TECHNICAL & POLICY REPRESENTATION

Reference: The Drovers Solar Farm Project (NSIP Application EN010142 / EN0110013)

RE: Deadline 4 Submission – Technical, Policy, Environmental, Deliverability, Compulsory Acquisition and Grid Connection Objections to the Proposed Drovers Solar Farm and Integrated 25-Acre Battery Energy Storage System (BESS).

DRAWING TITLE:
ES Figure 12.13 Work No. 2 Piling Locations within CSA for Maximum Groundwater Level

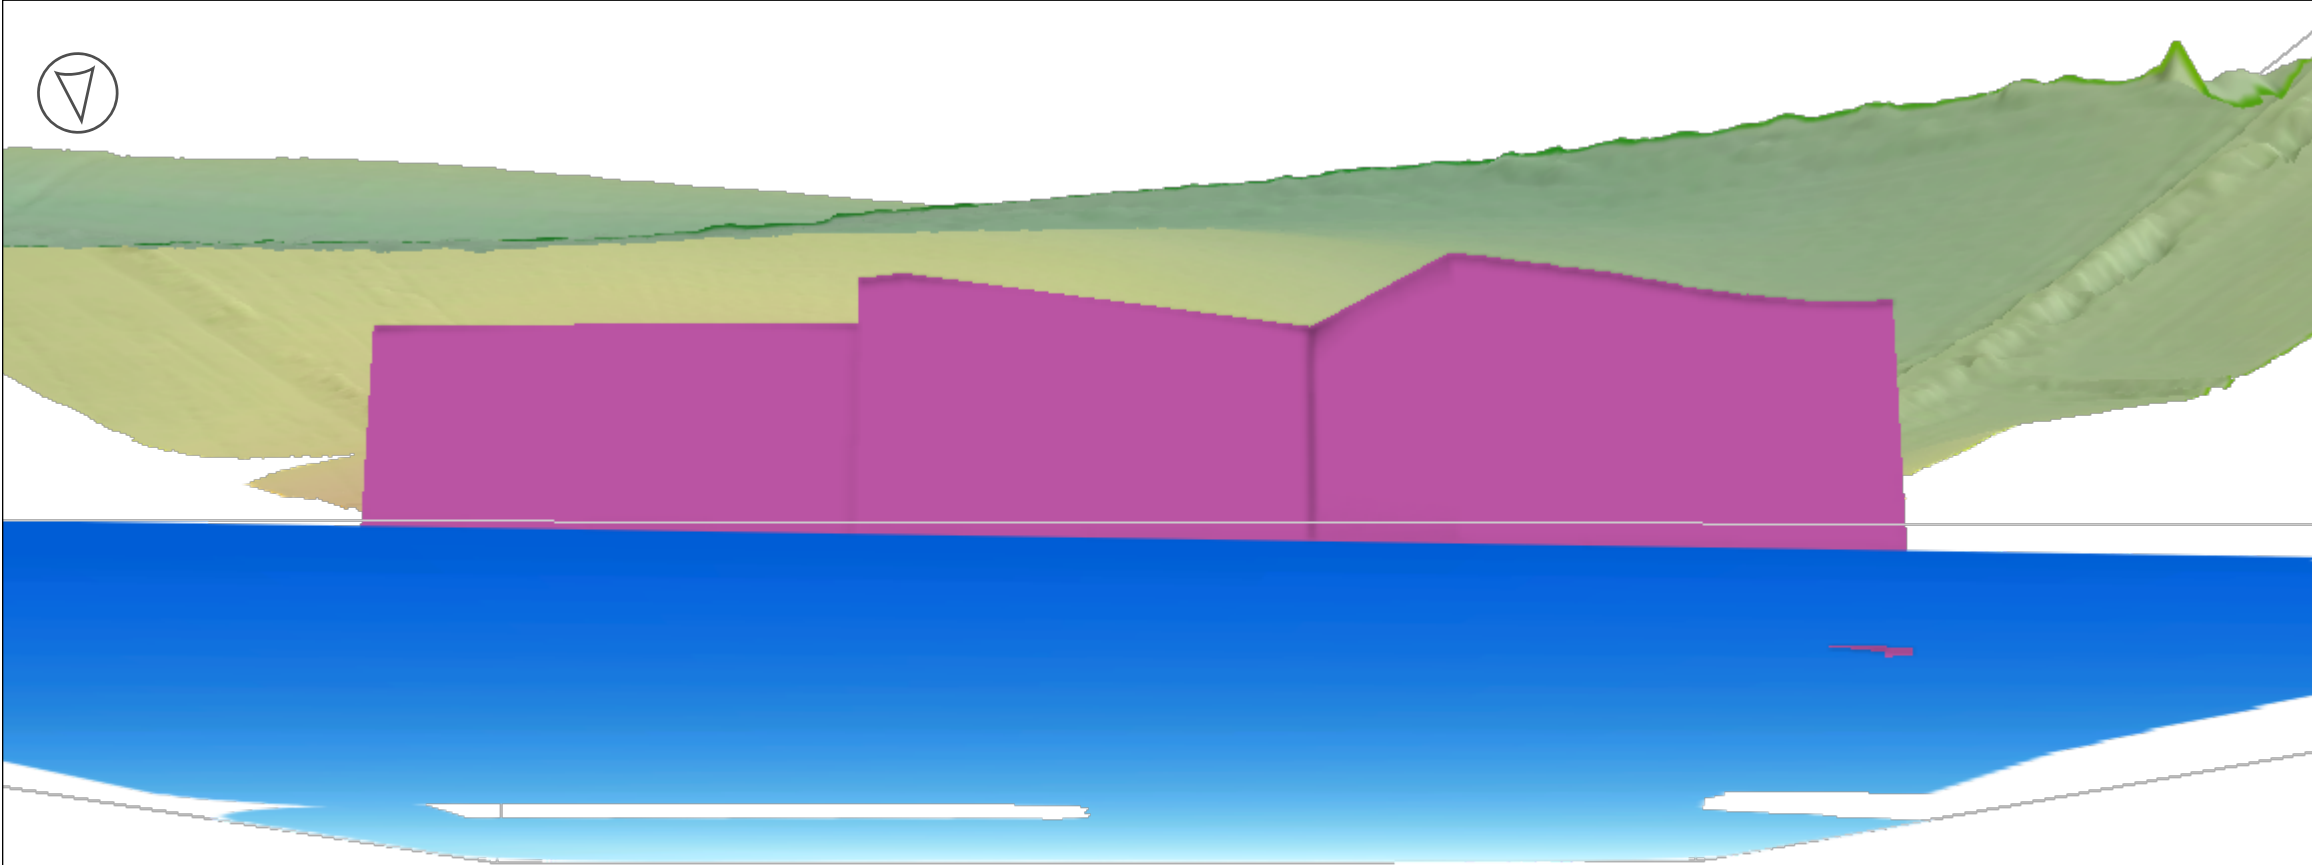
1. What are the exact geometric dimensions, storage capacities, and physical footprints of the underground tanks designated for clean firefighting water supply?
2. What are the exact geometric dimensions, storage capacities, and physical footprints of the underground containment tanks designated for capturing highly contaminated, toxic firefighting runoff water?
3. At what precise depth below natural ground level are these underground clean and contaminated water tanks to be physically positioned?
4. Will the excavation profile for these tanks penetrate local groundwater tables or sub-surface flood levels? If not, please indicate the exact floor and ceiling heights of these tanks relative to Ordnance Survey topographic height levels (AOD) to prove total isolation from regional water paths.
